# **AQUIND INTERCONNECTOR**

## **Environmental Statement Addendum – Appendix 1 Environmental Statement Errata Sheet**

Document Ref: 7.8.1.1

**DATE: 6 OCTOBER 2020**

DRAWING No: EN020022-2.9-EL-Sheet1	REV: 02
------------------------------------	---------

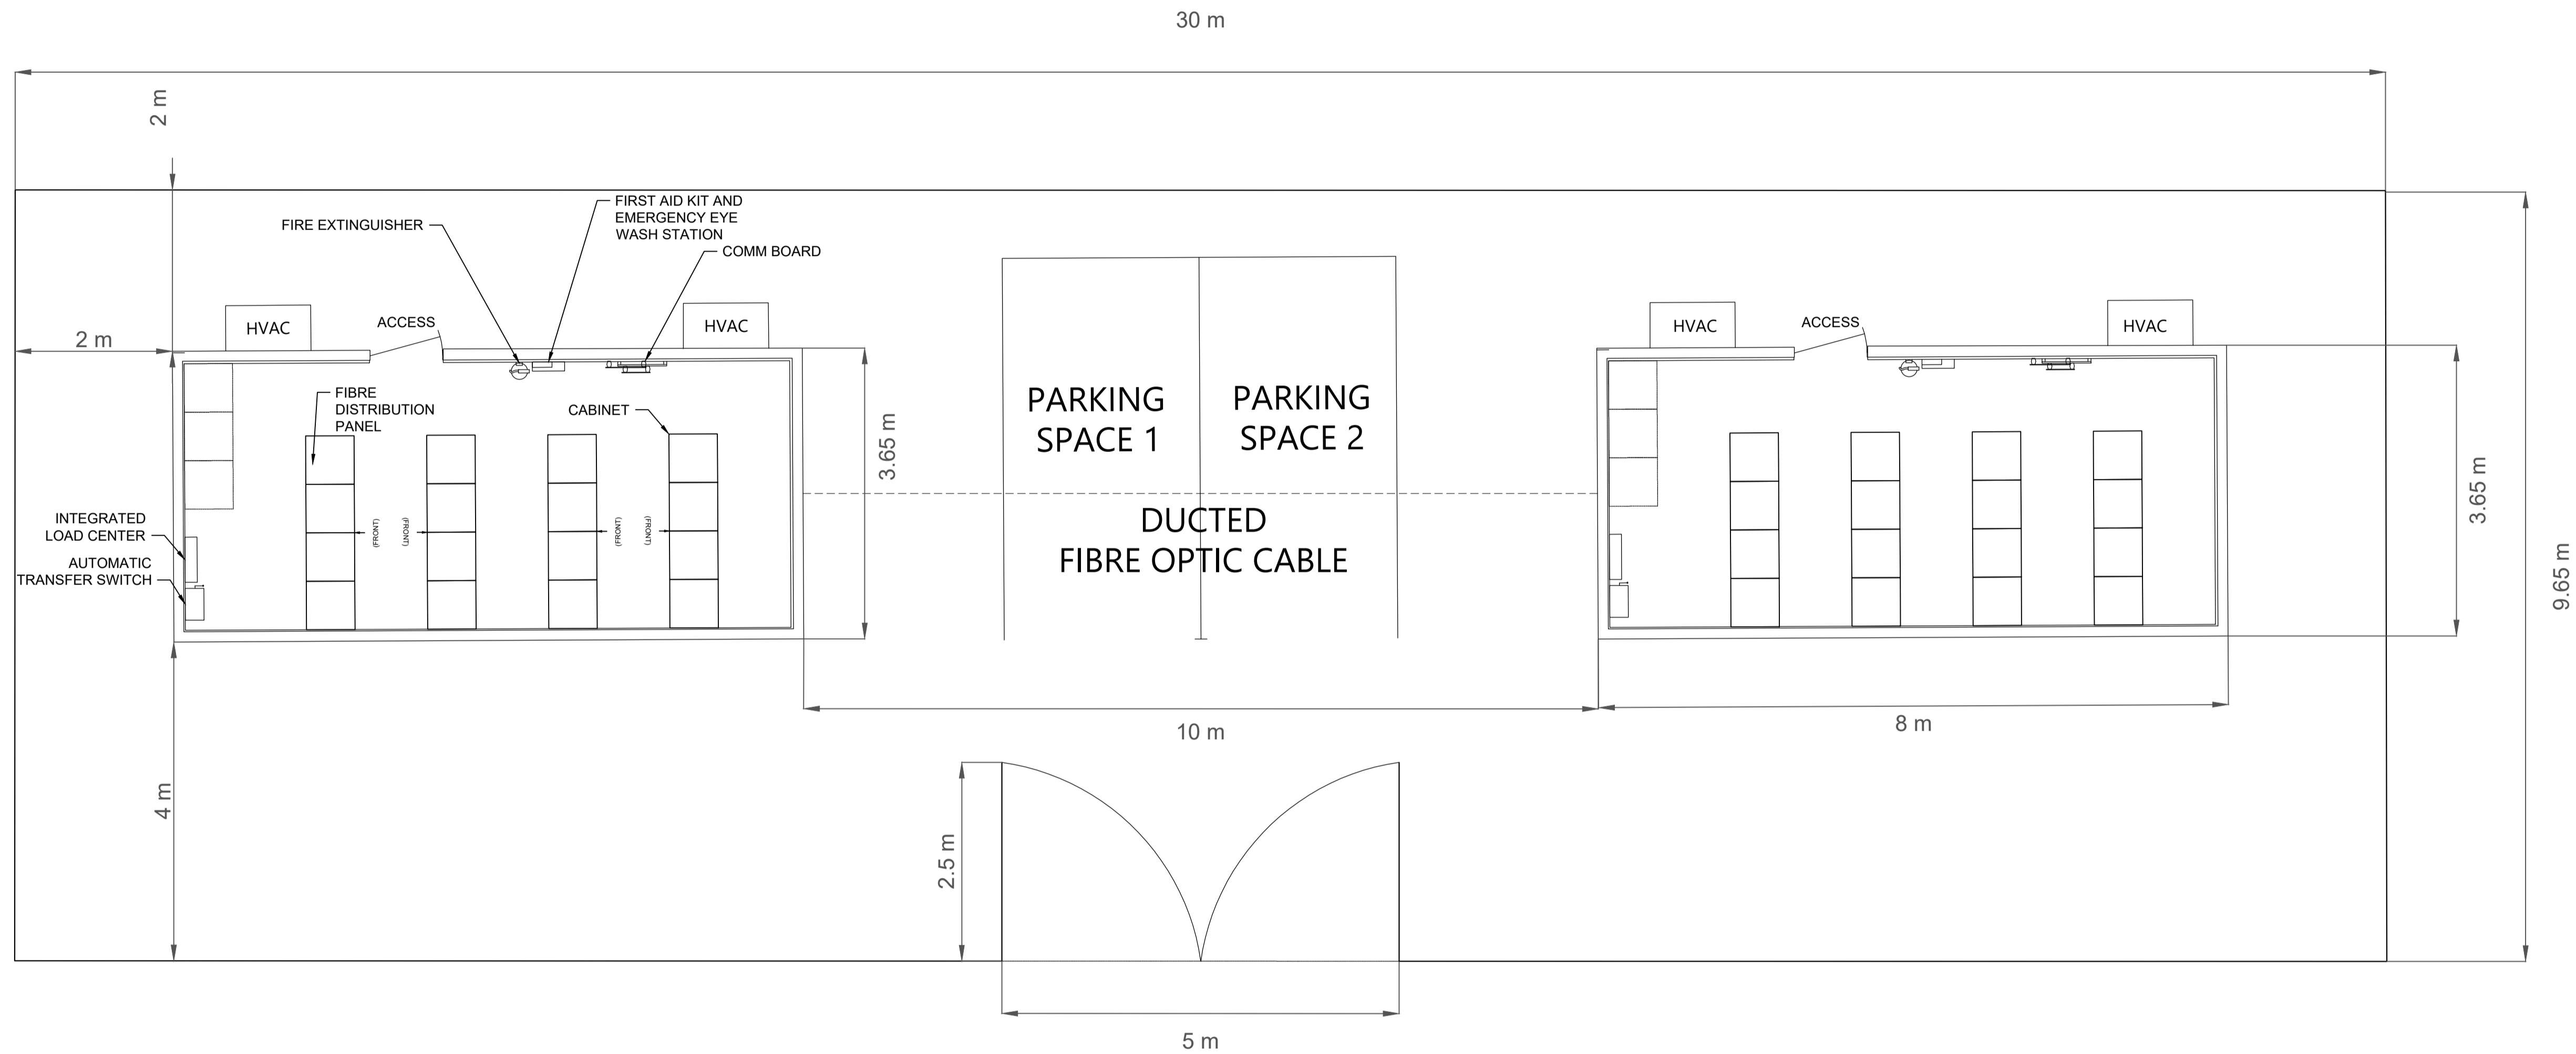
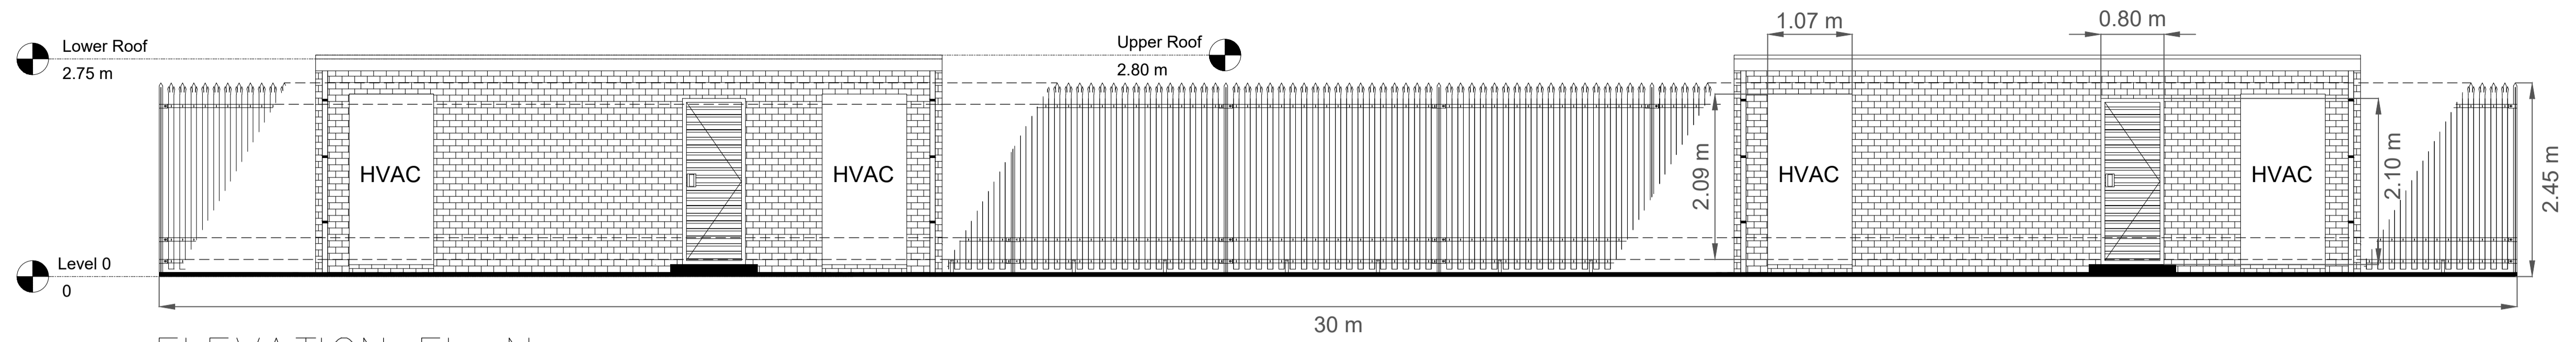
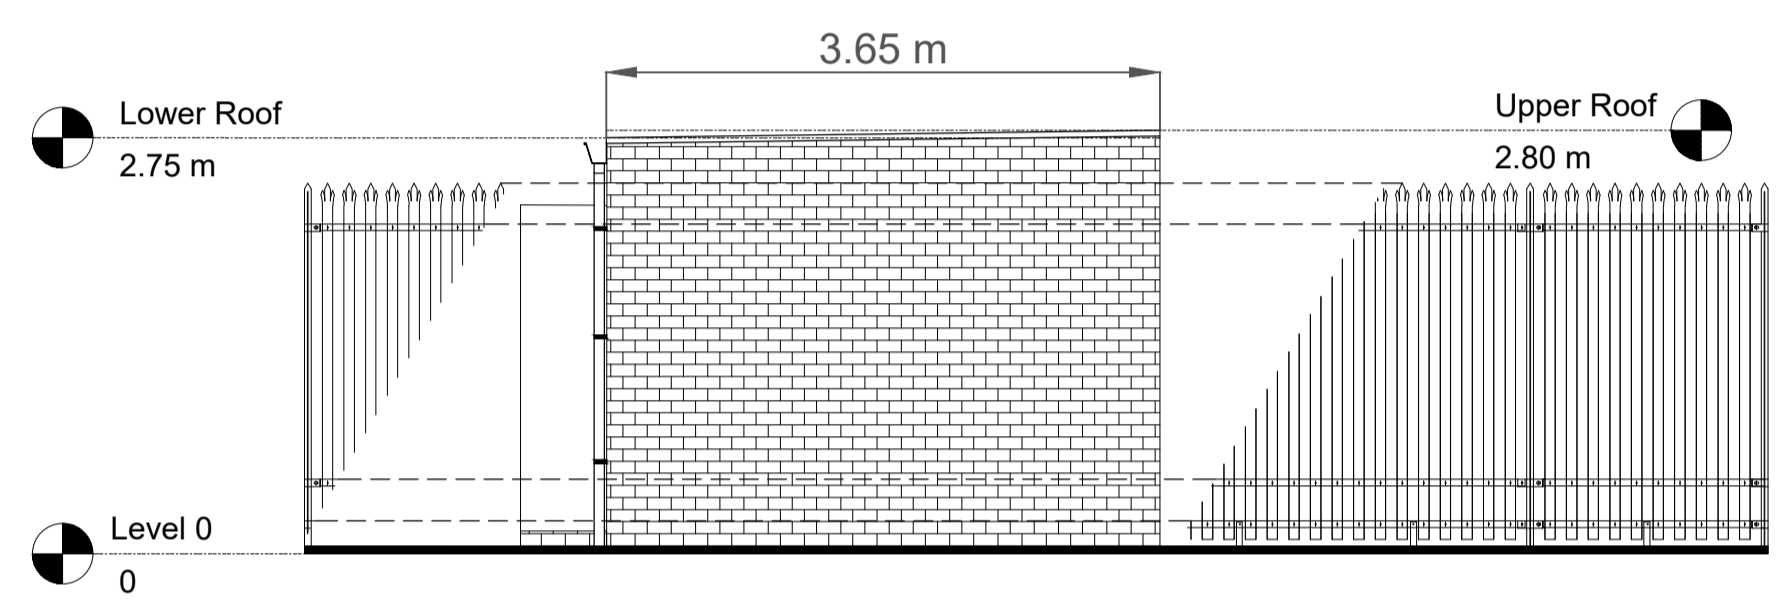
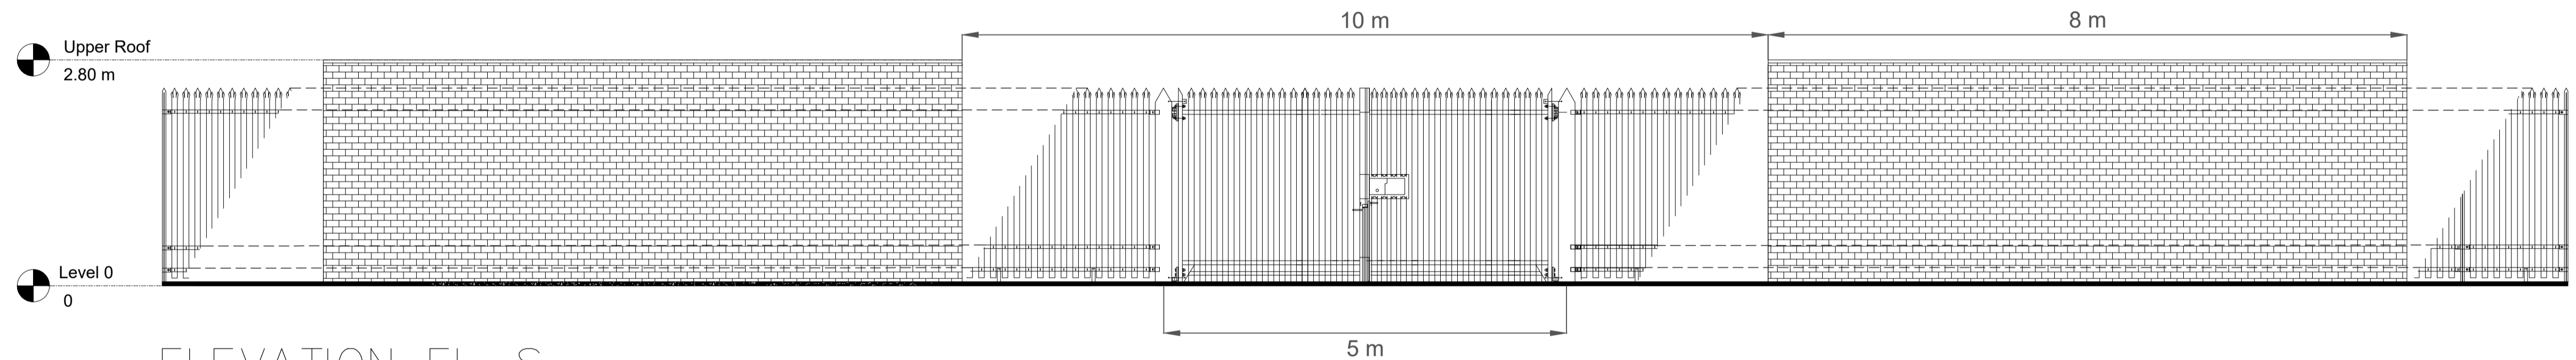
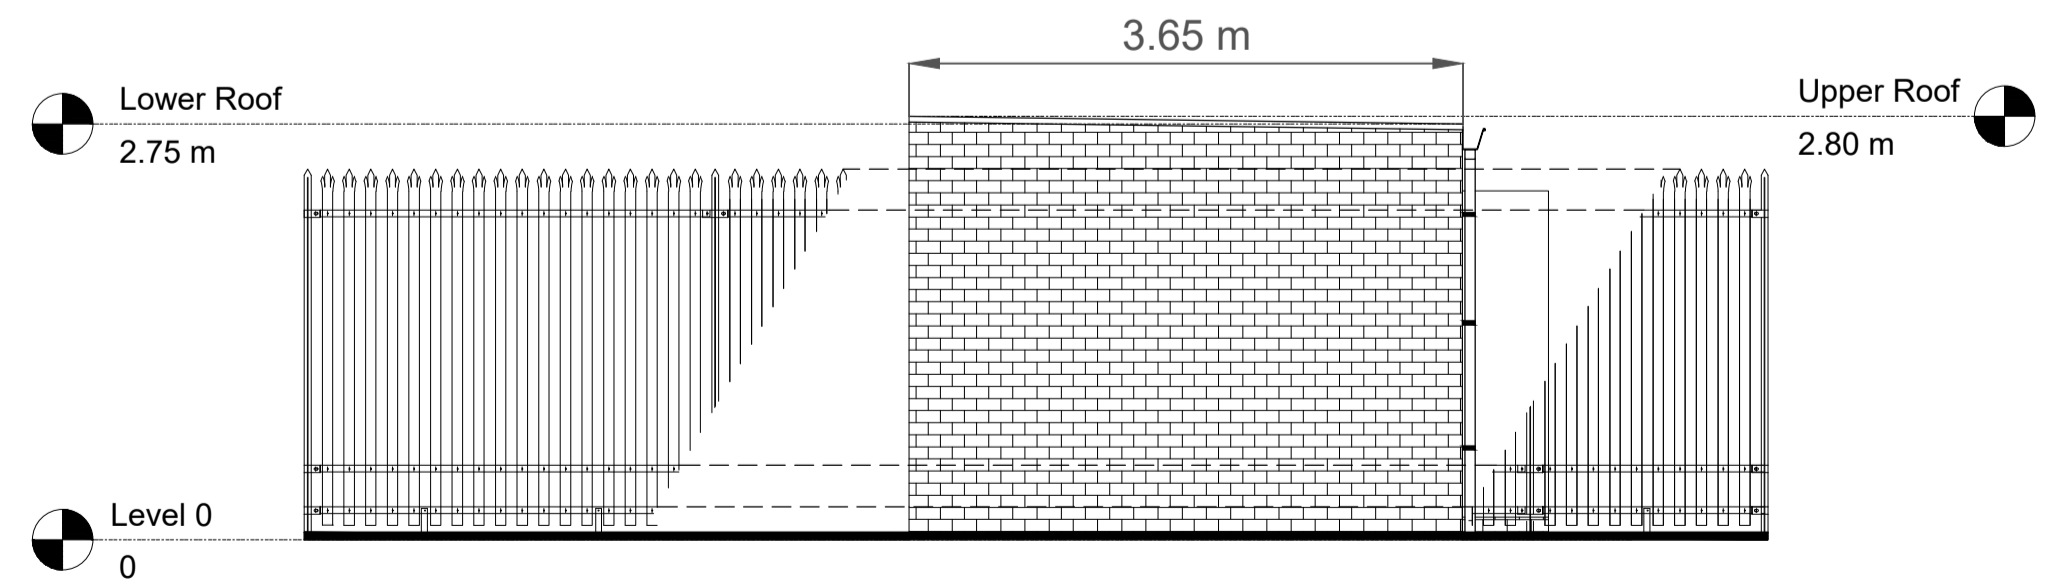
Location in the 2019 ES	Error noted in the 2019 ES	Amended text in ES Addendum
<b>Optical Regeneration Station(s) Parameter Plan (APP-017).</b>	bars and it is not clear what scale they should be printed or viewed at.	<ul style="list-style-type: none"> <li>• Indicative Telecommunications Buildings Elevations and Floor Plans (APP-015 Rev02);</li> <li>• Indicative Converter Station Area Layout Plans (APP-013 Rev02);</li> <li>• Indicative Optical Regeneration Station(s) Elevations and Floor Plans (APP-016 Rev02);</li> <li>• Optical Regeneration Station(s) Parameter Plan (APP-017 Rev02).</li> </ul> <p>Information relating to scale of the drawing and paper size is included within the drawing title block.</p>
<b>Funding Statement (APP-023)</b>	Paragraph 7.2.1 – incorrect reference to paragraph 7.4.3 instead of 7.2.3	Reference updated to refer to paragraph 7.2.3 instead.
<b>Marine Outline CEMP (APP-488)</b>	Paragraph 5.6.2.2 is incomplete	<p>Text has been updated to be read as follows:</p> <p><i>“Contractors will ensure that Cable Laying Vessels (‘CLV’) will display appropriate marks and lights, and broadcast their status on AIS at all times, to indicate the nature of the work in progress, and highlight their restricted manoeuvrability.”</i></p>

Location in the 2019 ES	Error noted in the 2019 ES	Amended text in ES Addendum
		<p>measures listed at Table 28.15 which are embedded within the Construction Stage’.</p> <p>For 28.6 in the ‘ES Source (Para)’ column it should state ‘<i>Table 28.19</i>’ and not ‘Table 28.17’.</p> <p>In the ‘Subject/ Potential Impact’ column it should state ‘<i>Embedded mitigation within the of the Converter Station design</i>’ and not ‘within the of the Converter Station design Embedded mitigation’.</p> <p>In the ‘Mitigation Measures (as set out in the ES)’ column it should state ‘<i>The mitigation measures listed at Table 28.19 which are embedded within the design of the Converter Station</i>’ and not ‘The mitigation measures listed at Table 28.15 which are embedded within the design of the Converter Station’</p>
<p><b>Indicative Telecommunications Buildings Elevations and Floor Plans (APP-015);</b></p> <p><b>Indicative Converter Station Area Layout Plans (APP-013);</b></p> <p><b>Indicative Optical Regeneration Station(s) Elevations and Floor Plans (APP-016);</b></p>	<p>The Indicative Telecommunications Buildings Elevations and Floor Plans, Indicative Converter Station Area Layout Plans, Indicative Optical Regeneration Station(s) Elevations and Floor Plans and Optical Regeneration Station(s) Parameter Plan appear to lack scale</p>	<p>The following plans have had scale bars added and have been resubmitted with this document:</p>
